Our Case Number: ABP-318573-23

Re: A proposed Road Development comprising of the N2 Slane By-Pass and Public Realm Enhancement Scheme
Within the Townlands of Slane, County Meath

Observations on

N2 Slane Bypass and Public Realm Enhancement Scheme Project Website

Figure 4.2: Outline of the Proposed N2 Slane Bypass and Public Realm Enhancement Scheme

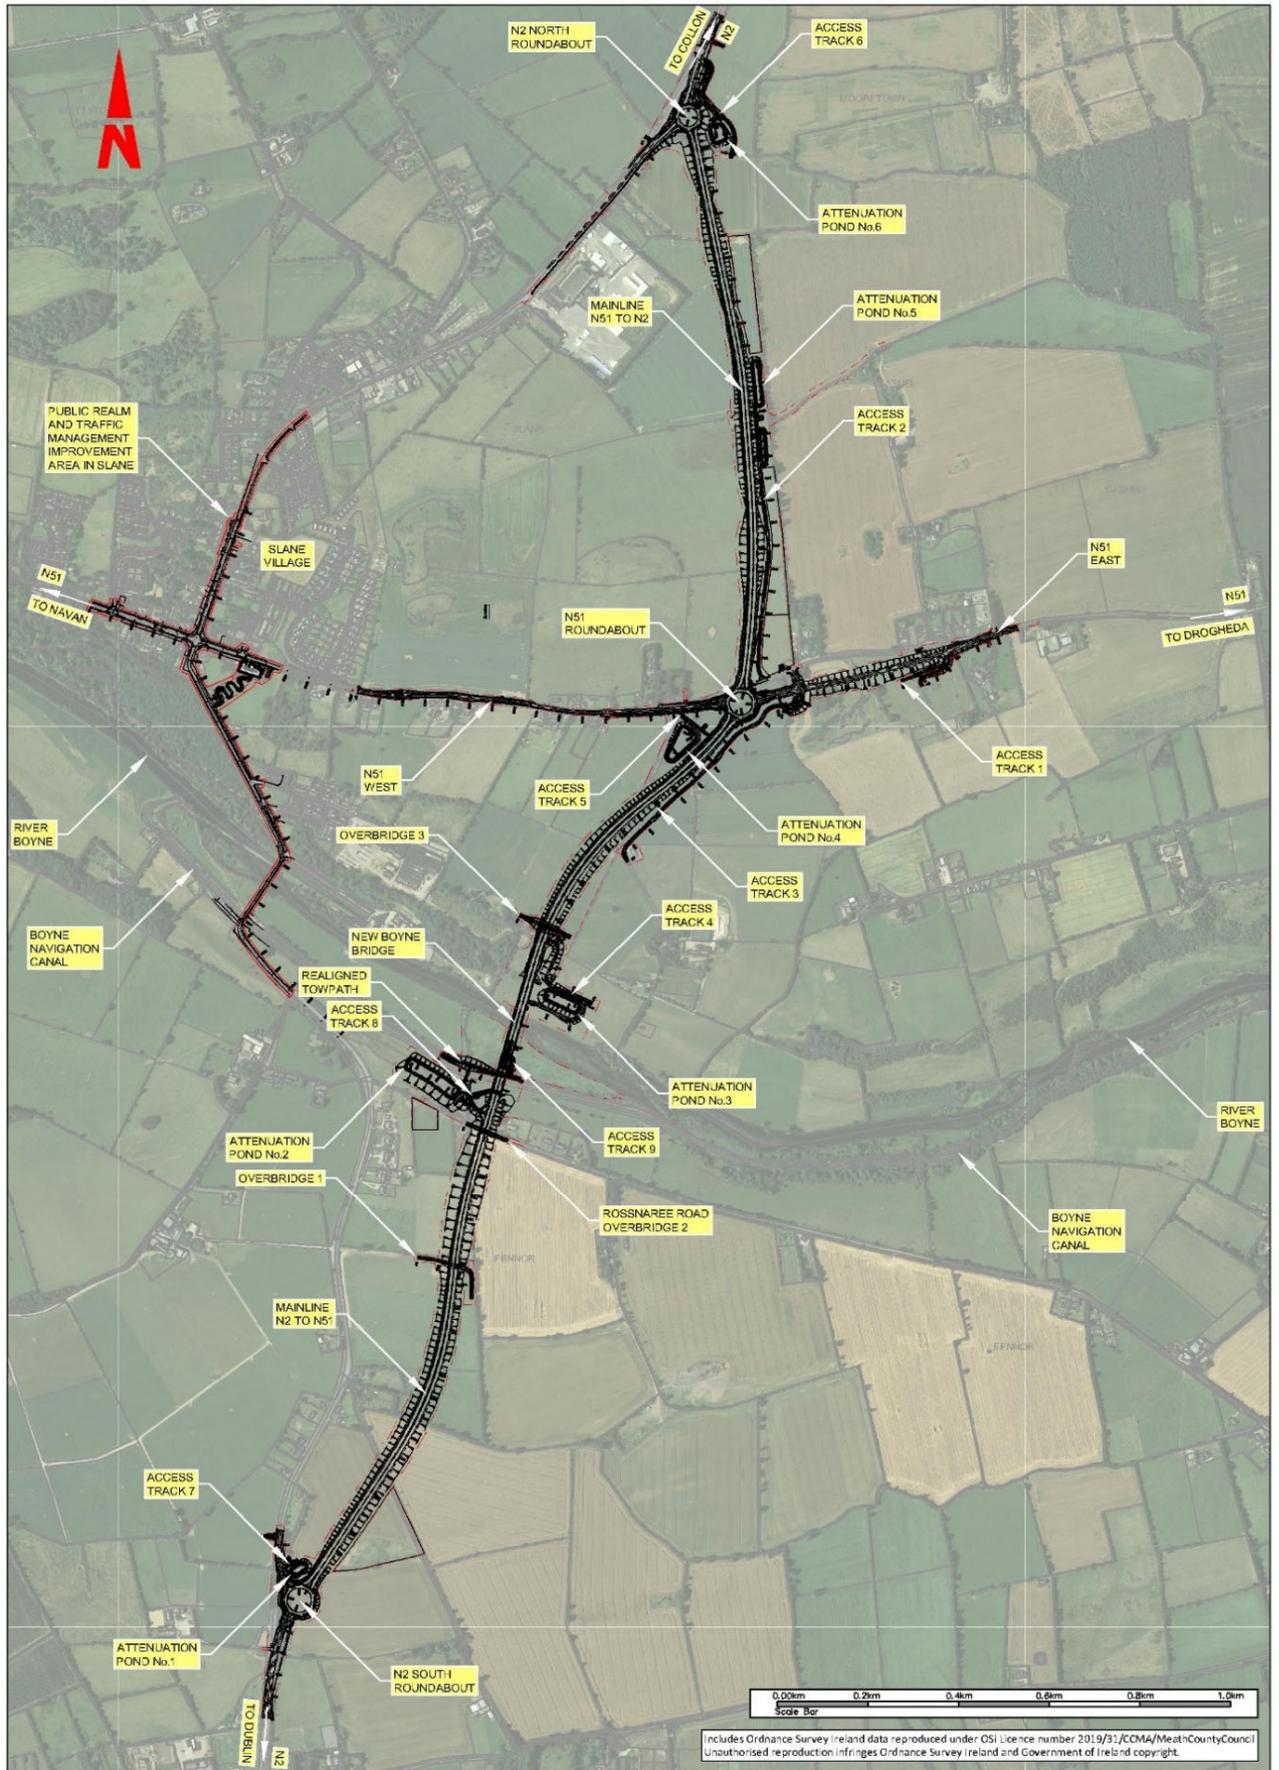
- Why does the scheme start just south of McGruder's Cross instead of at McGruder's Cross? McGruder's is the main access point to Newgrange from the N2. There is currently a sharp bend just south of the cross. Placing the proposed roundabout at McGruder's Cross would significantly improve traffic safety by providing a safe interchange to the world heritage site, eliminating two junctions in close proximity to each other and removing the bend.

Figure 4.18: Proposed Extent of Slane Public Realm Enhancement

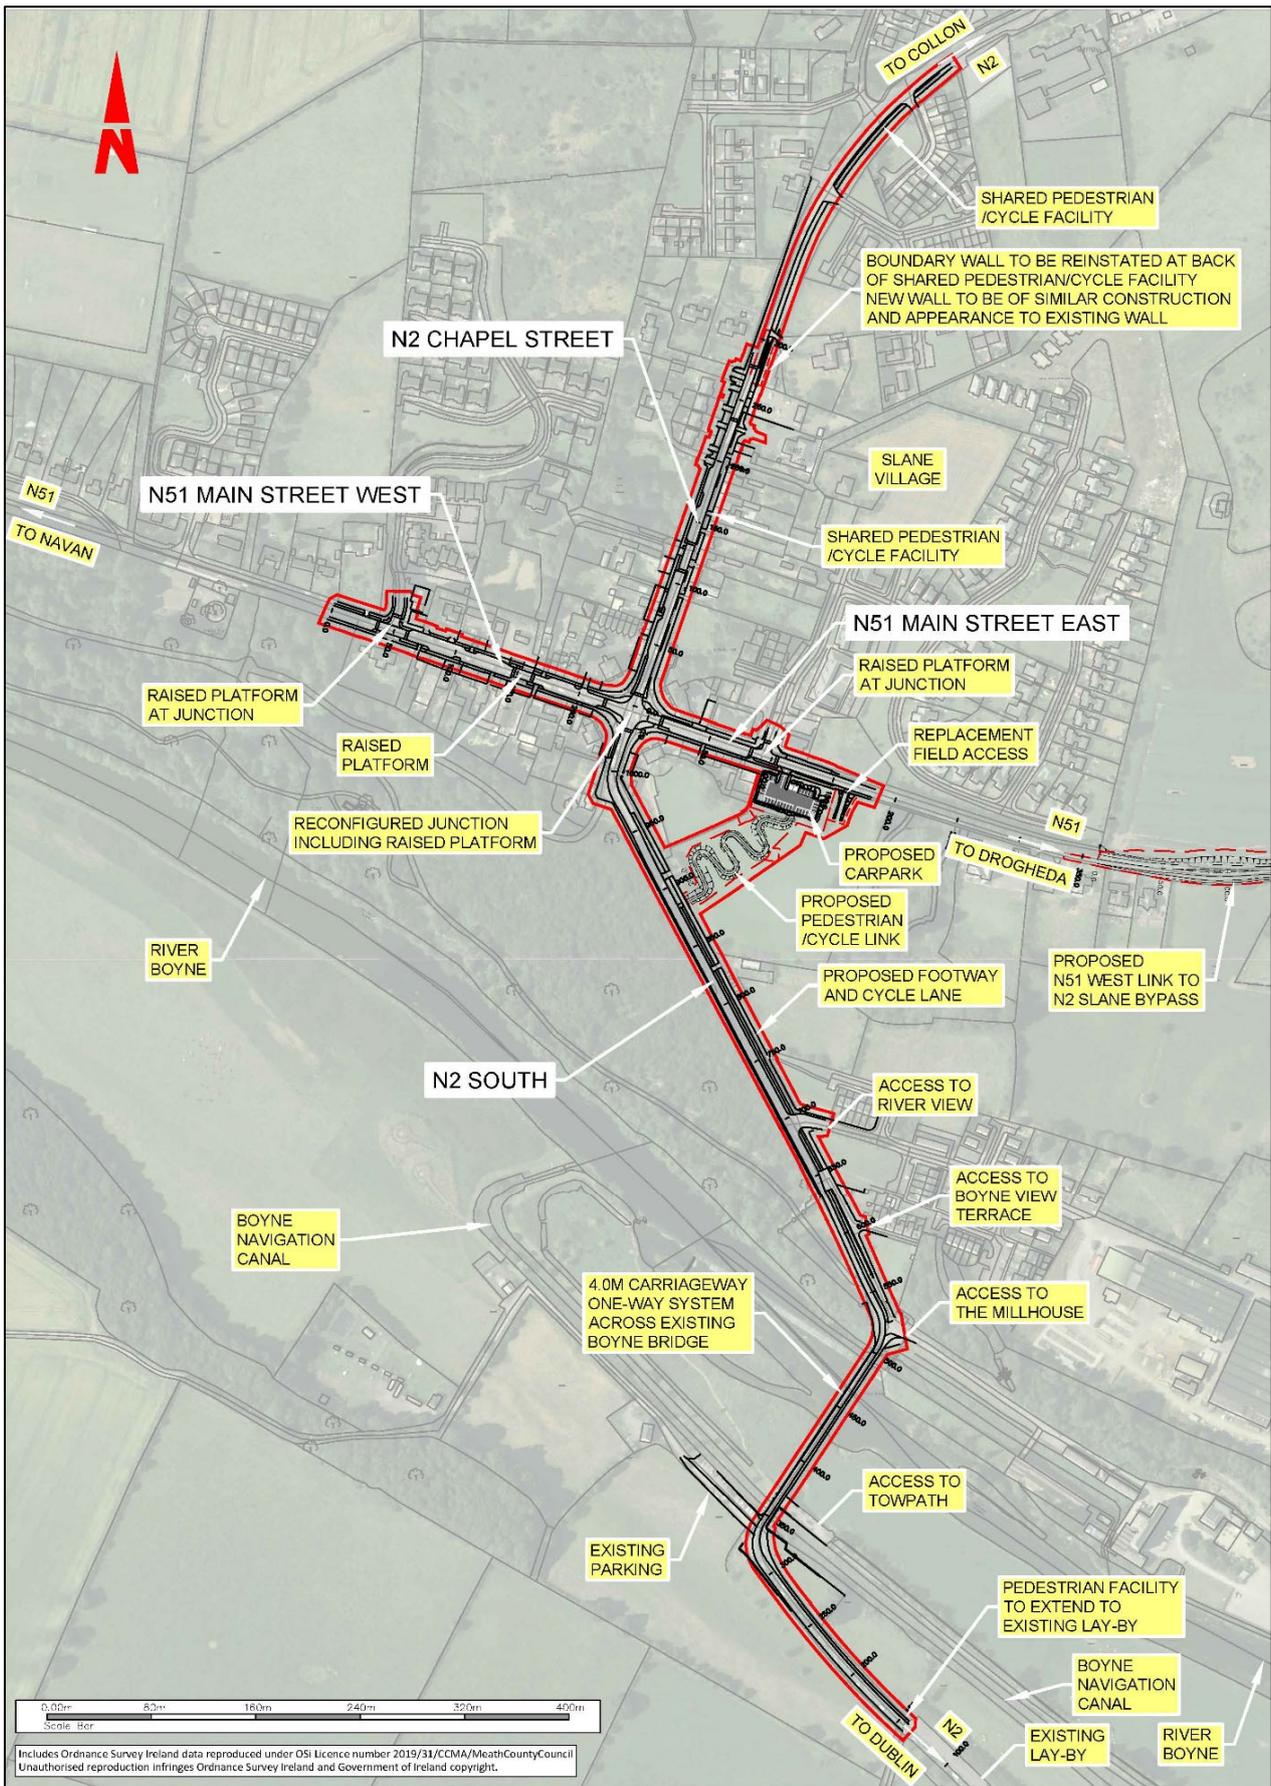
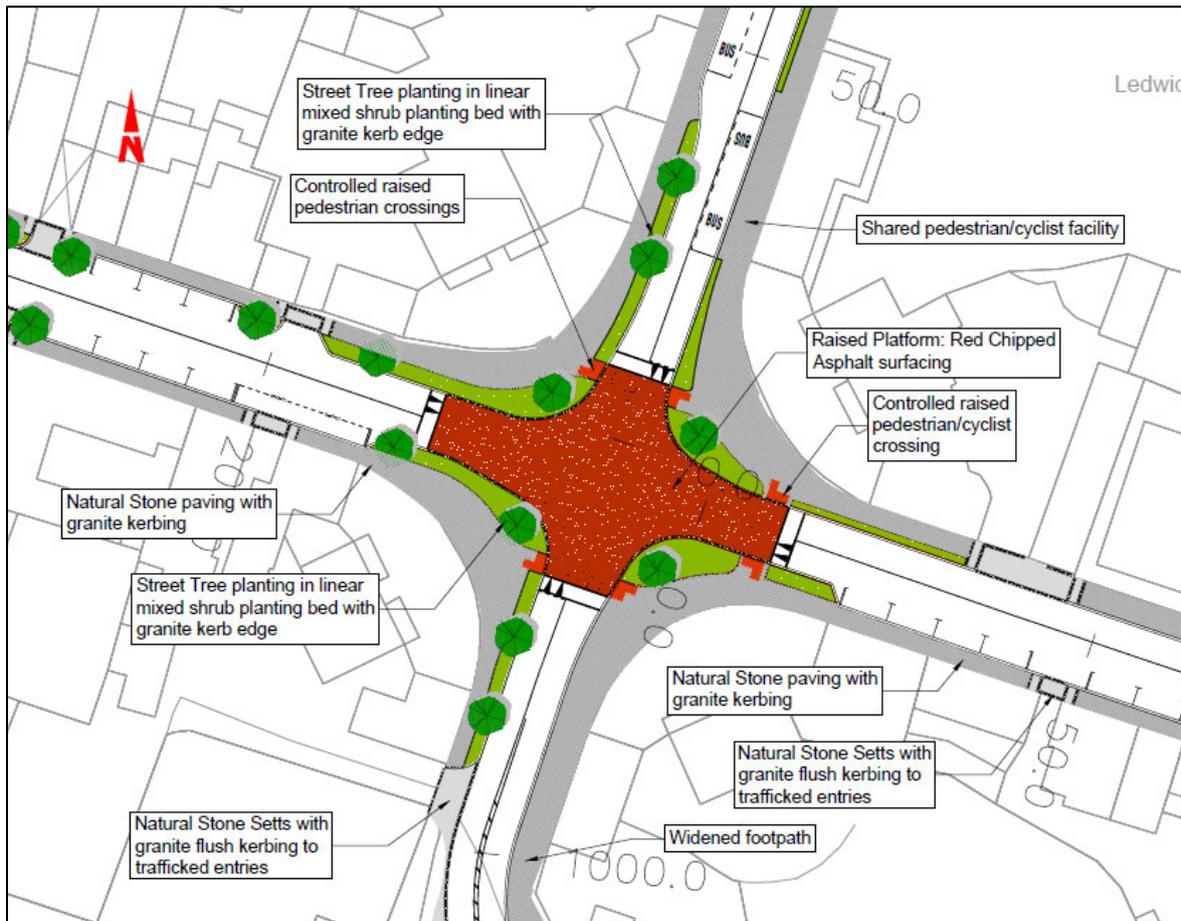
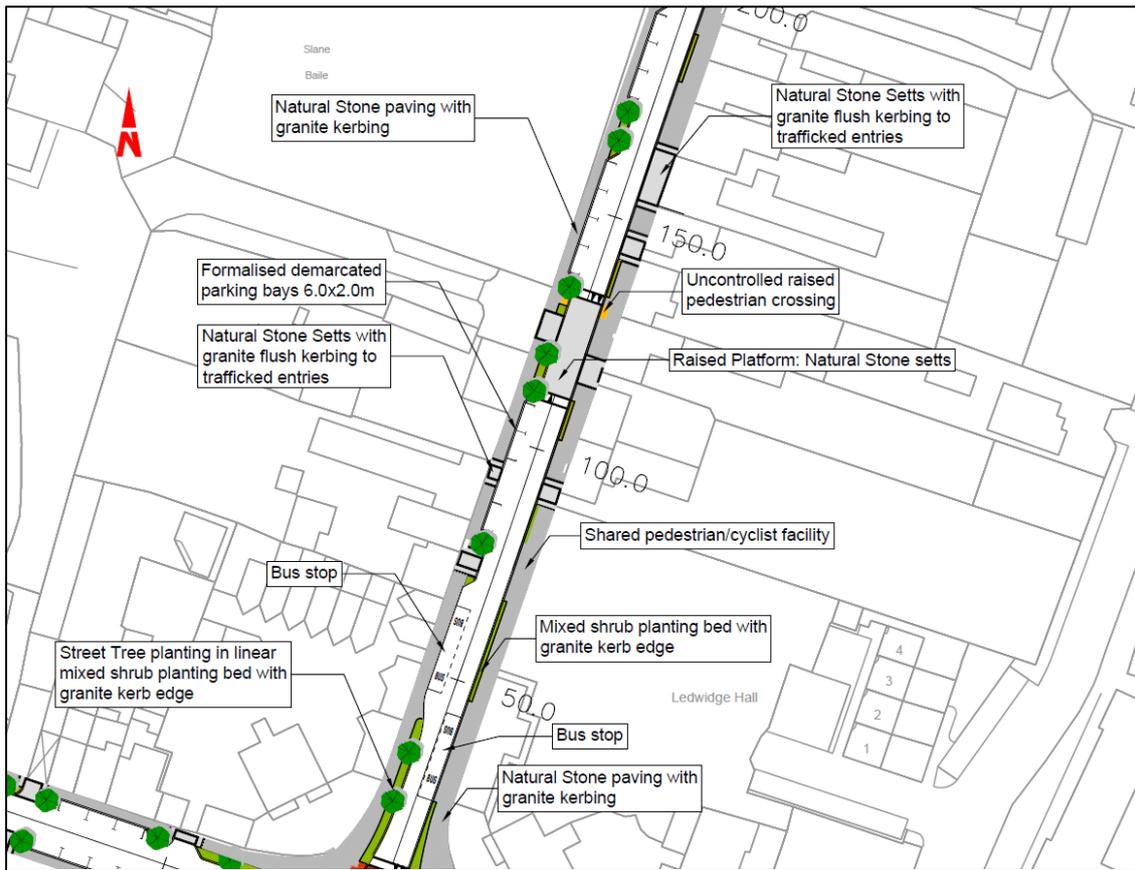
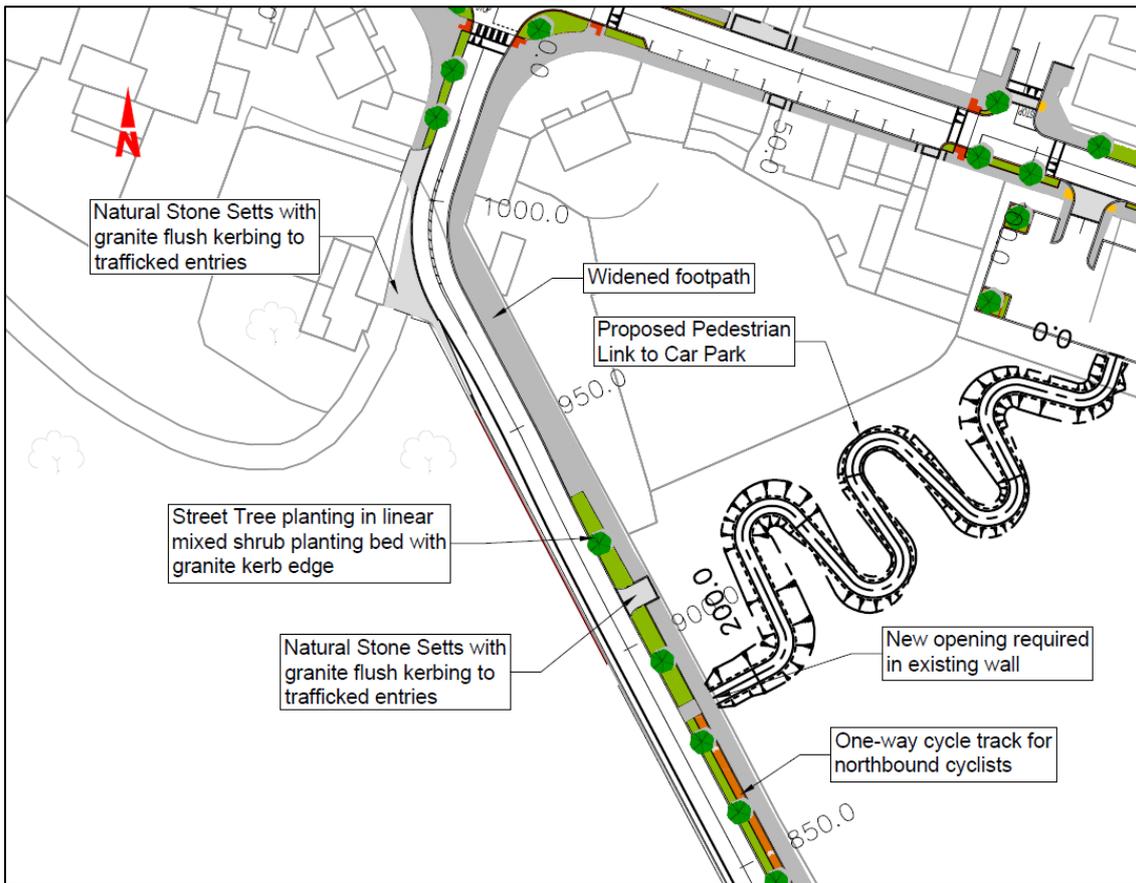
- Slane Village is a planned eighteenth century Estate Village and is designated as an architectural conservation area. The design of the enhancement scheme, and in particular the pallet of proposed materials chosen, is inappropriate for this setting eg limestone paving and cobbles would be more appropriate that white granite and red tarmac. No provision has been made for bus shelters and some of the proposed planting will actually obscure the view of some of the historic buildings.
